**RE: Transmittal of Comments – Badger Bluff Short Plat (SP-09-00010)**

RE: Badger Bluff Short Plat SP-09-00010

TO: Jeff Watson, Community Development Services  
FROM: Christina Wollman, Planner II *cw*  
DATE: August 19, 2009  
SUBJECT: Badger Bluff Short Plat SP-09-00010

BADGER BLUFF SHORT PLAT
 A PORTION OF THE NW 1/4 OF SEC. 8, T.17N, R.20E., W.M.
 KITTITAS COUNTY, WASHINGTON

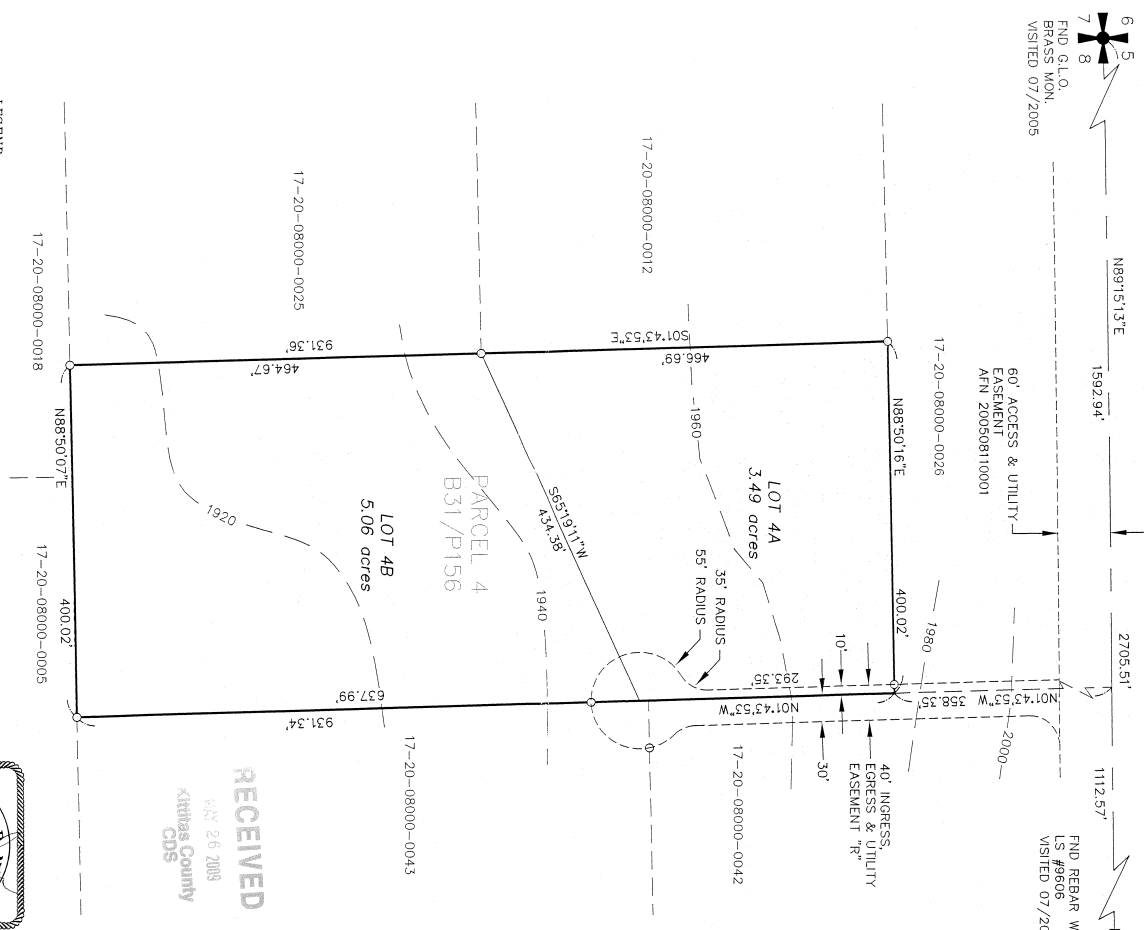
3. Clerf Road Intersection: The intersection at Clerf Road shall be improved to meet sight distance requirements as stated in WSDOT Design Manual Figure 920-6 for roads with a AWDVTE of 100 to 1500 and speed limit of 50 mph. The required sight distance is 425 feet. The final design shall be approved by Public Works prior to final approval.

4. Easement “R”: The easement shall be recorded prior to final approval, and the recording number shown on the plat.

5. Access to Clerf Road: The entire easement to Clerf Road shall be shown. The easement may be shown in the vicinity map if clearly labeled.
6. Private Road Improvements: Access from Clerf Road to Easement "R" shall be constructed as a Low-Density Private Road. See Kittitas County Road Standards, 9/6/05 edition.

7. Private Road Improvements: Easement "R" shall be constructed to meet or exceed the requirements of a High-Density Private Road that serves 3-14 tax parcels. See Kittitas County Road Standards, 9/6/05 edition.

8. Cul-de-Sac: A cul-de-sac turn-around having an outside right-of-way or easement diameter of at least 110 feet shall be constructed at the closed end of all dead-end roads serving 3 or more lots. The driving surface shall be at least 96 feet in diameter. Cul-de-sacs must also conform to the requirements specified by the 2006 International Fire Code. Contact the Fire Marshal regarding any additional cul-de-sac requirements.
